## Andrew Beattie - The Issues Associated with the Design of the Proposed Relocation of the BerryEquestrian Centre

**From:** Heidi Hewitson <heidi.hewitson@bigpond.com>  
**To:** "plan\_comment@planning.nsw.gov.au" <plan\_comment@planning.nsw.gov.au>  
**Date:** 14/12/2012 7:53 AM  
**Subject:** The Issues Associated with the Design of the Proposed Relocation of the BerryEquestrian Centre

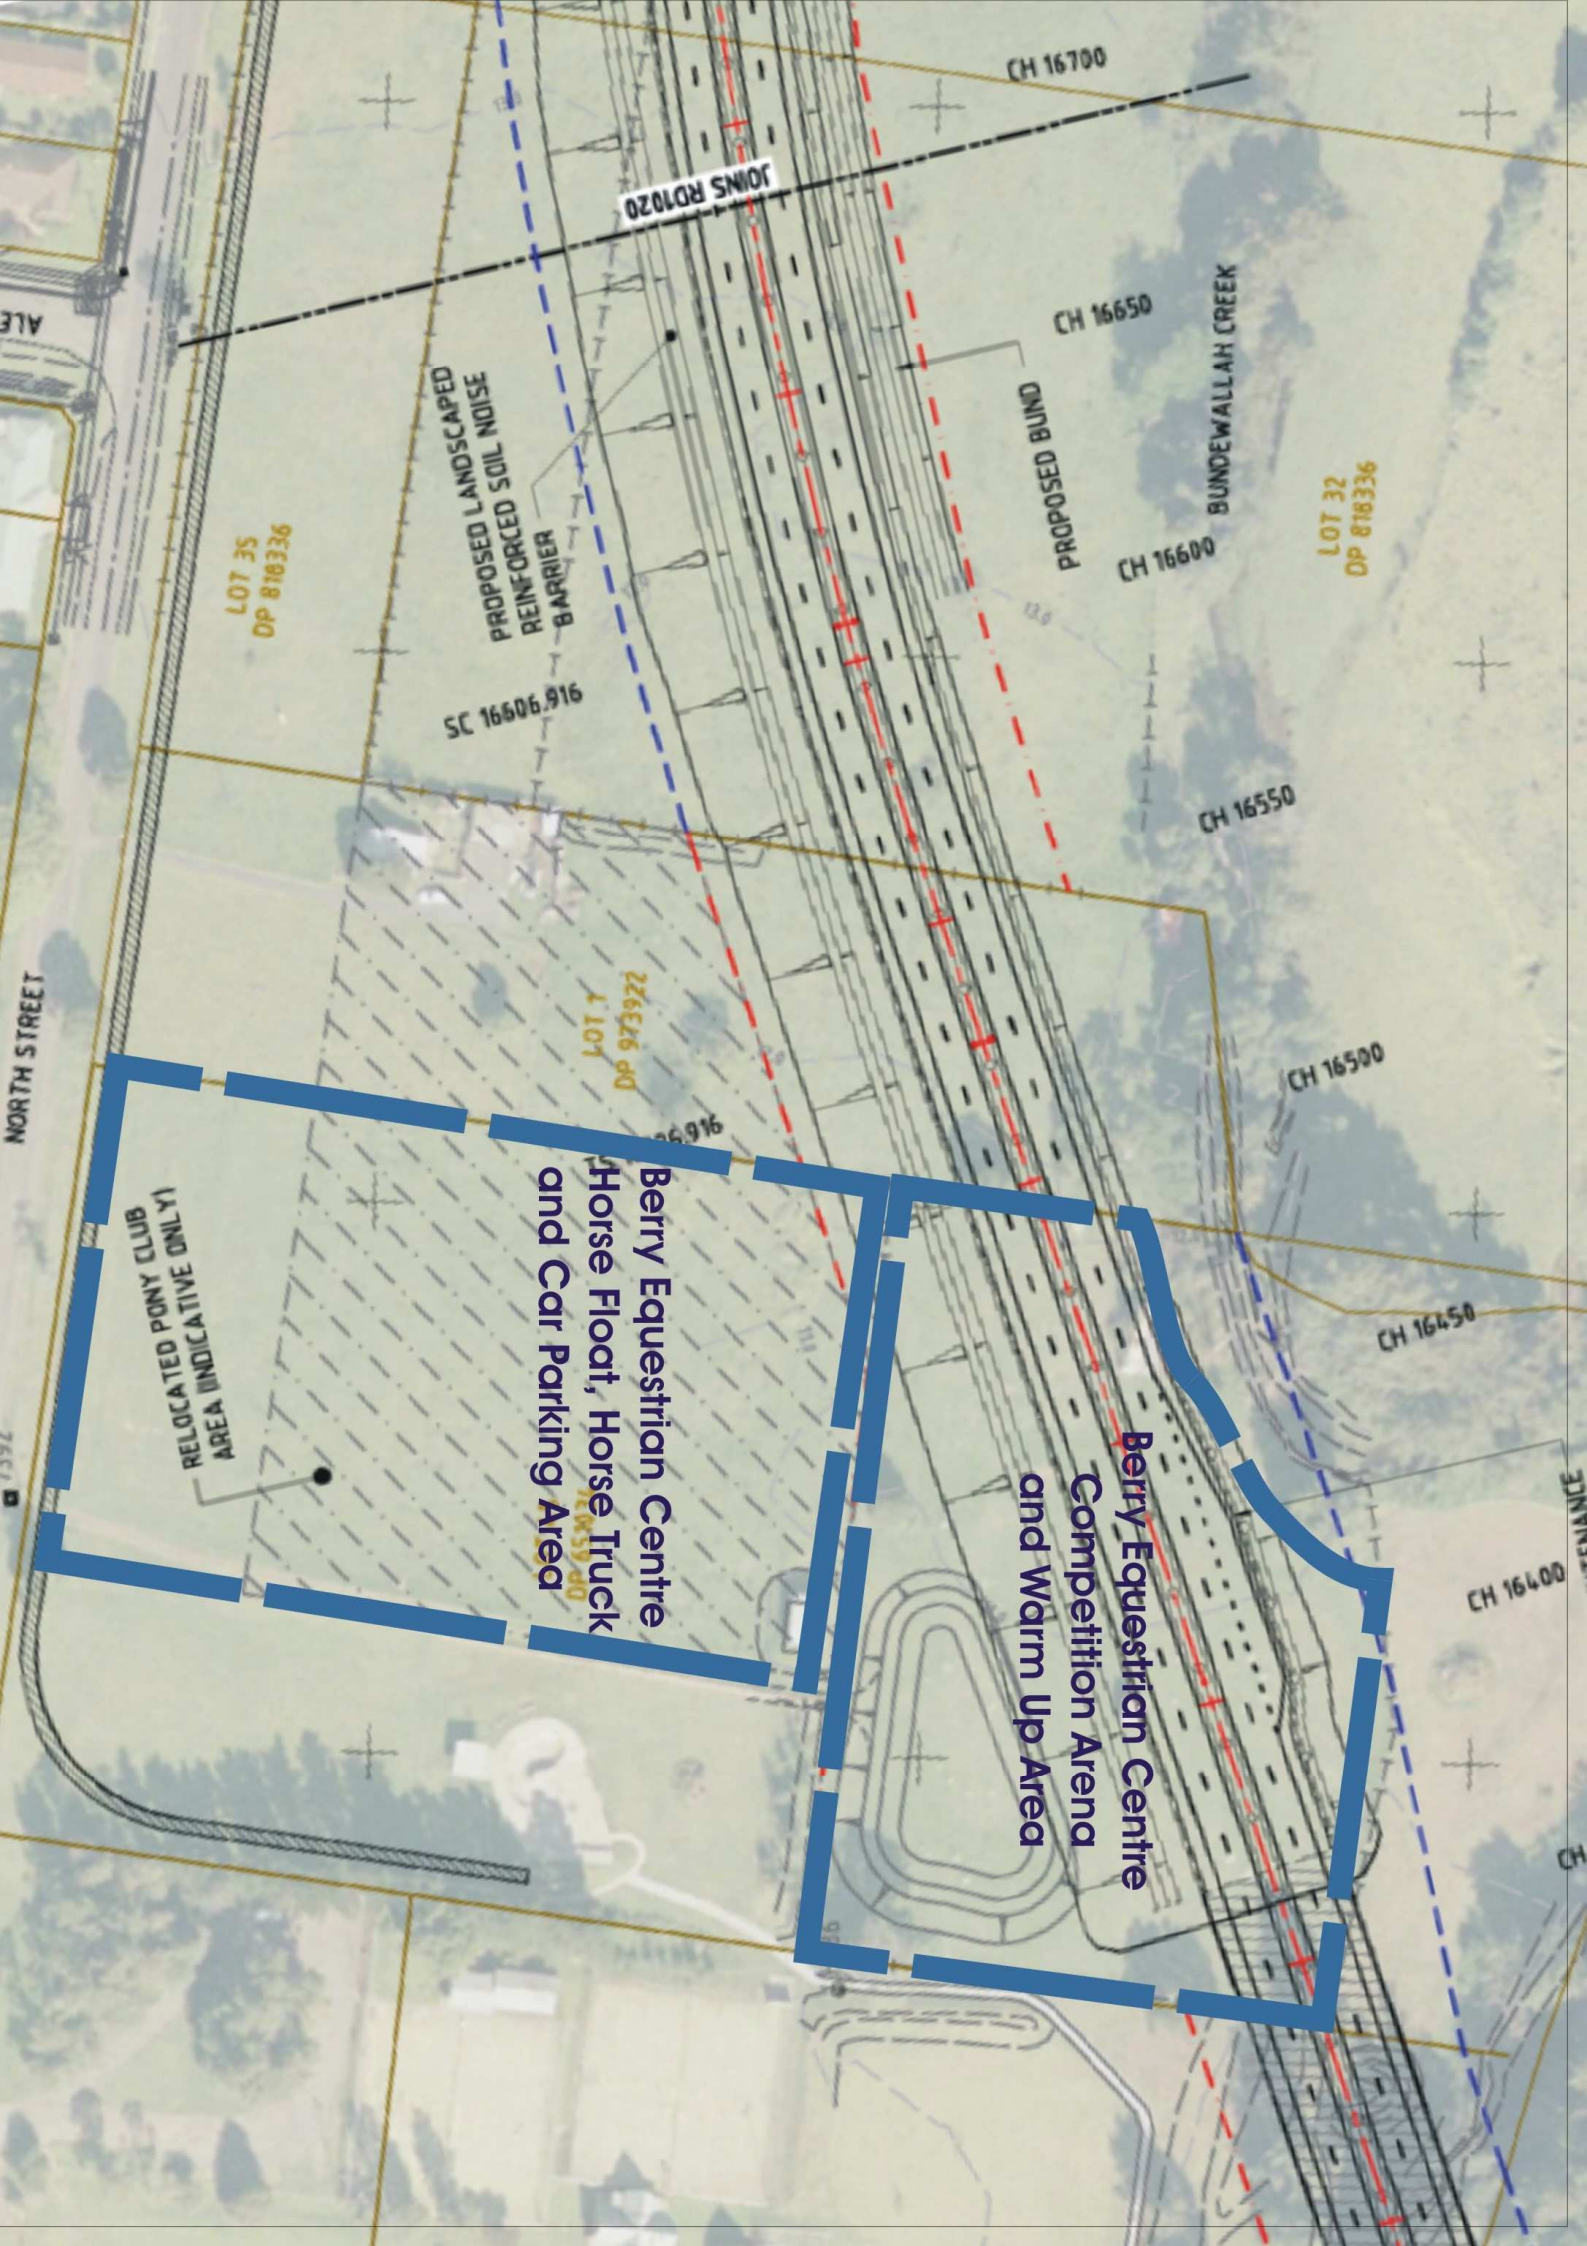
I object to the bypass going through the Berry Equestrian Centre. The design and loss of land of the proposed relocation of the Berry Equestrian Centre will have a significant impact on the ability to conduct events. It will impact riders, participants and spectators in the following ways.

1. The competition grounds are required to be rectangular /square in shape of a minimum size of 140 metres x 140 metres with a level, well drained, good riding surface in order to cater for at least 4 dressage arenas or 2 showjumping arenas.

2. The parking area is required to be of a minimum area equivalent to 90 metres x 160 metres and allow for easy entry, maneuverability, parking and exit of horse floats and trucks. Each parking space is equivalent to an absolute minimum of 4 normal vehicle spaces due to the need for unloading/loading and tie up areas for horses.

3. There is concern for the safety of horses, riders and the general public due to the near location of the proposed riding area to the 4 lane expressway, the skateway, the public cycleway/walkway and North Street. There will be anticipated significantly increased noise and visibility of cars and trucks travelling at 100km/hour on the expressway with horses competing nearby, often with young, very inexperienced riders.

4. Access to the grounds is likely to be across a public shared cycleway/pathway. The safety of children on skateboards, bicycles etc are at risk as horse trucks and floats cross the pathway. Horse floats and trucks also require an indented driveway of at least 15 metres to allow vehicles to park off the roadway whilst gates to the grounds are opened.
